From: [REDACTED]
Sent: 27 August 2026 16:22
To: [REDACTED]
Subject: URGENT: Planning Committee tonight – formal objection to permanent access via Ingleton Crescent, application 3/2025/0997

I am contacting you urgently regarding planning application 3/2025/0997, which I have only just learned is being considered by the Planning and Development Committee tonight.

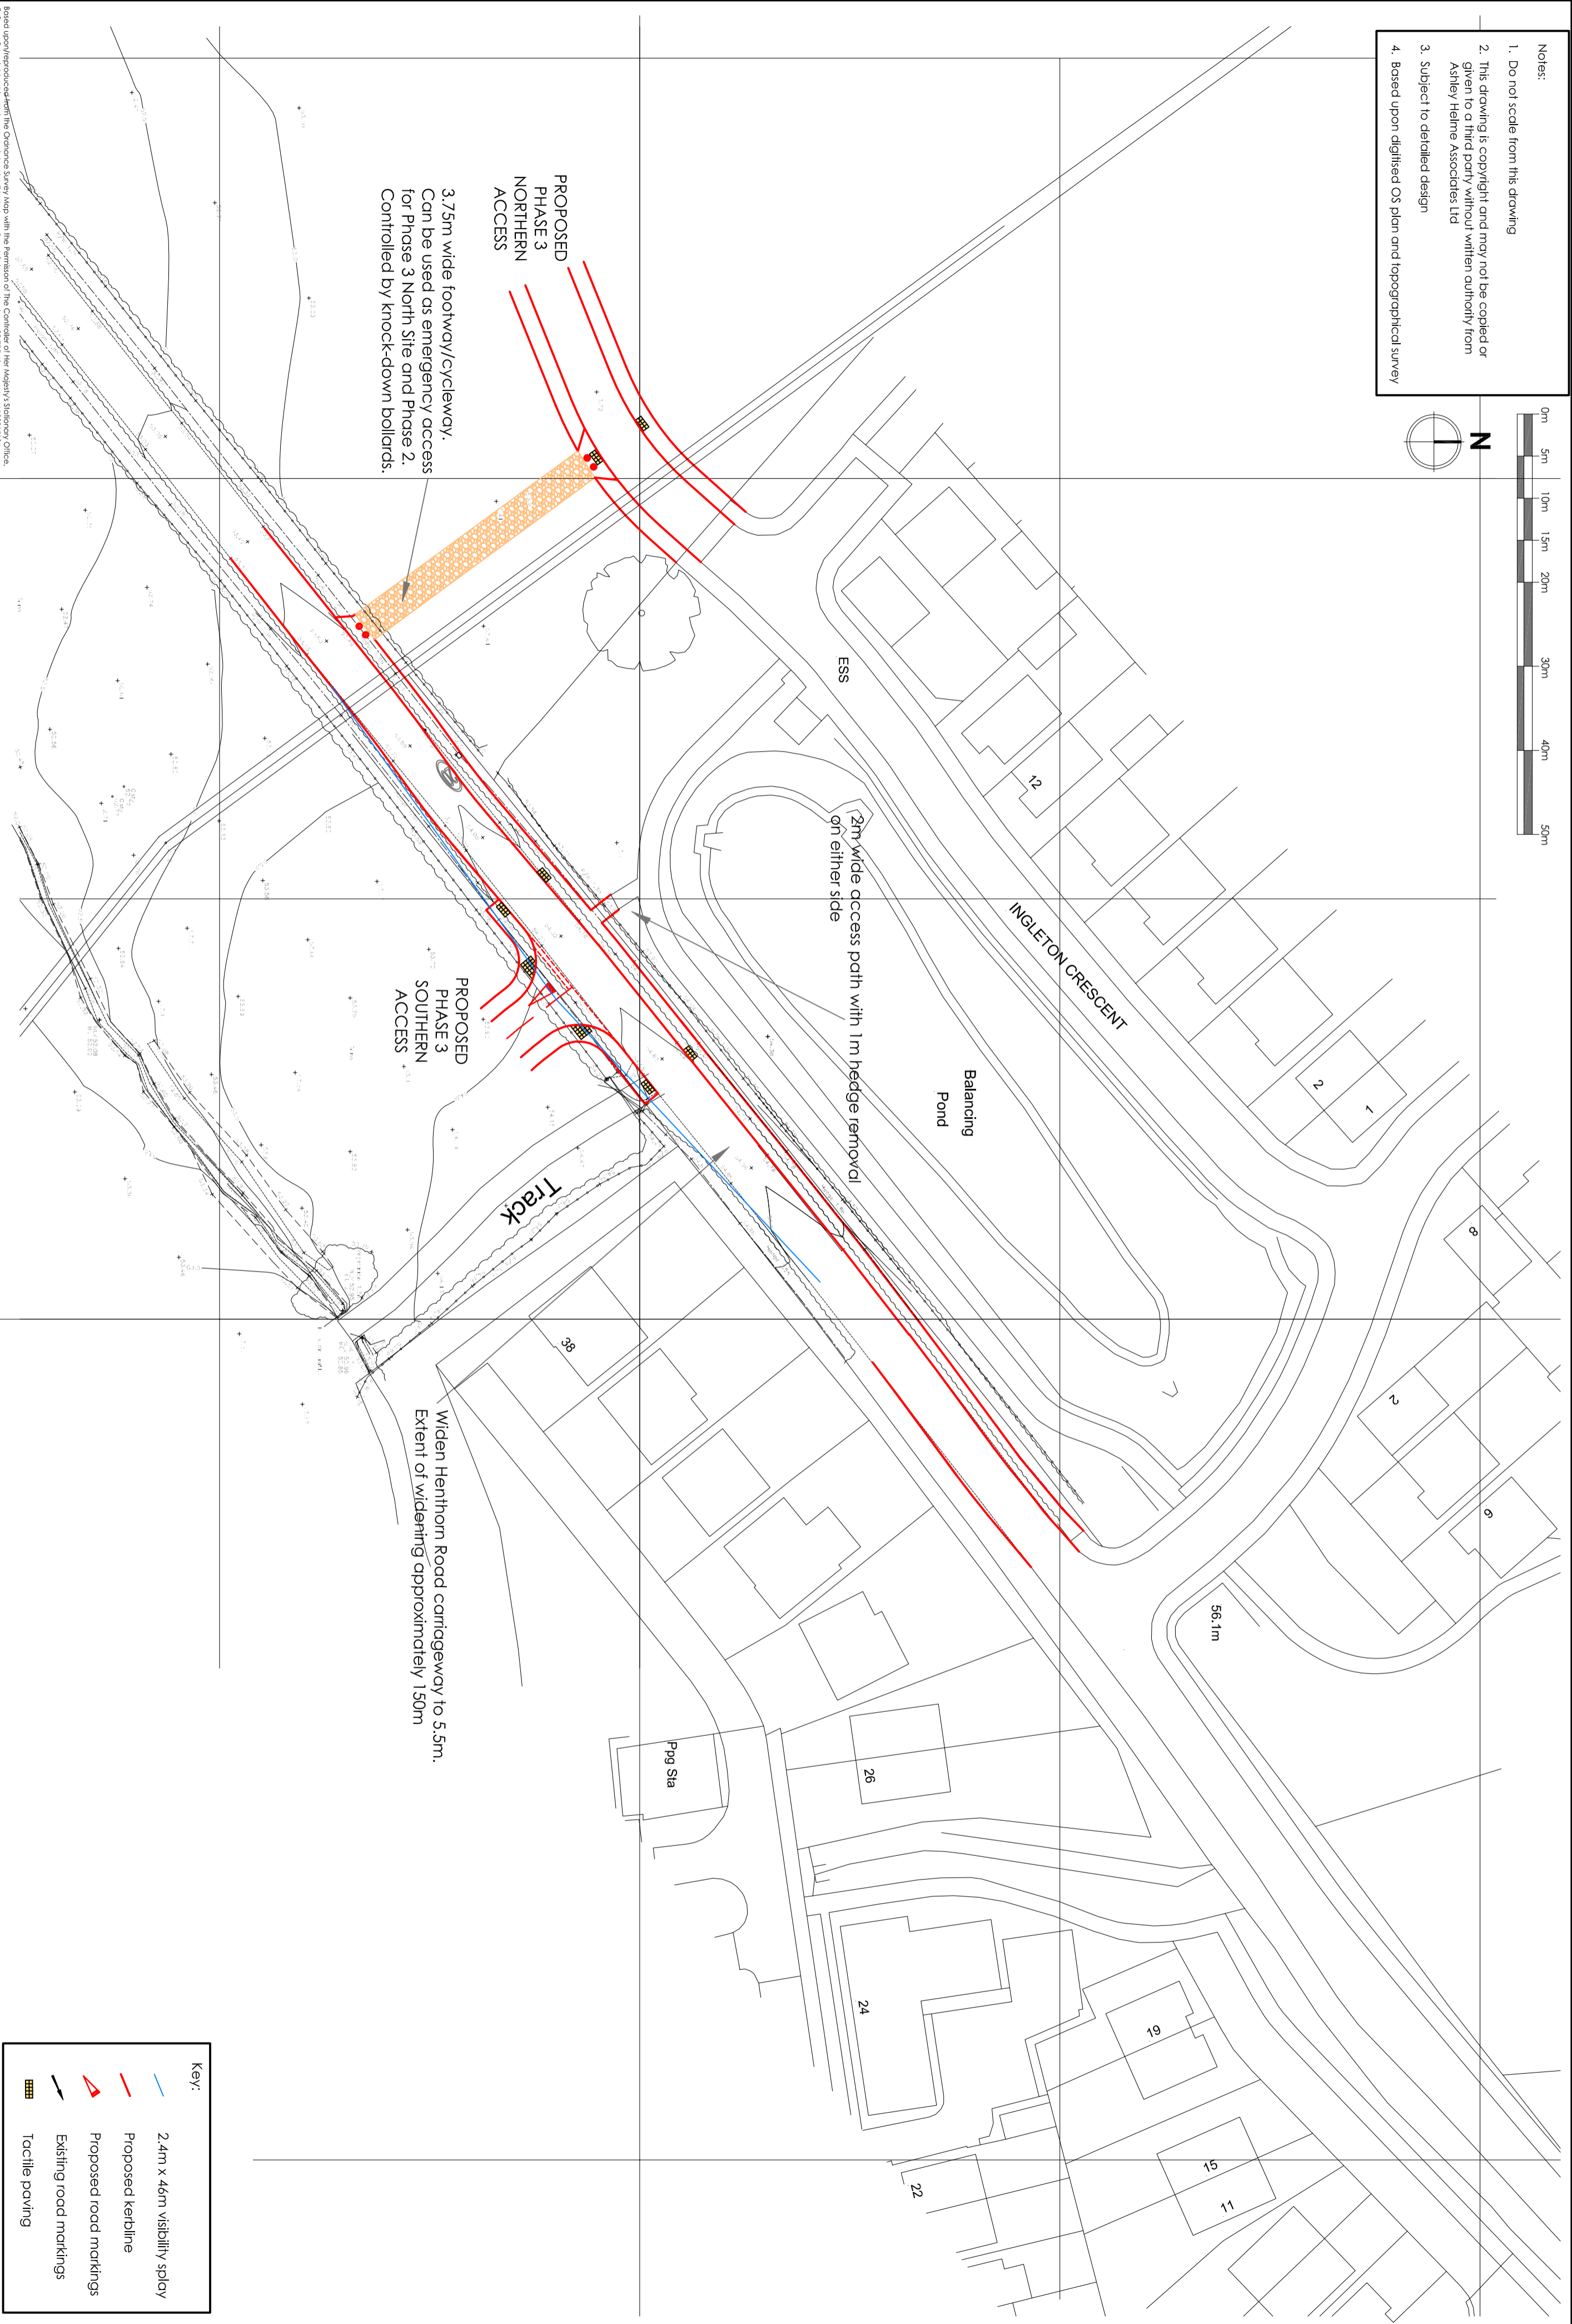
My principal concern is the proposal for permanent vehicular access to the northern part of the development through Ingleton Crescent.

I recognise that the proposed conditions would prevent construction traffic from using Waterfall Gardens and Ingleton Crescent. That is welcome, but it does not address the lasting problem. The published Local Highway Authority response expressly states that the northern part of the development would ultimately be accessed through Ingleton Crescent once occupied.

This would permanently change a quiet residential crescent into an access route serving an additional housing development.

I am particularly concerned that the Local Highway Authority regards Ingleton Crescent as unsuitable for construction traffic because of conflict with residential traffic and on street parking, yet considers the same route acceptable for permanent residential access. Although construction vehicles are clearly different in size, the identified conflicts with residents, parking and highway safety do not disappear once the homes are occupied. They become a permanent daily issue.

It is also significant that this is an outline application in which all matters are reserved except access. Access is therefore not a detail that can simply be resolved later. Tonight's decision could establish the permanent use of Ingleton Crescent as the vehicular entrance to the northern development.

5. Consider whether permanent access should be limited to walking, cycling and emergency use, rather than making Ingleton Crescent the everyday vehicular route into another estate.
6. Ensure that no decision is taken until the directly affected residents have had a fair opportunity to address committee members.
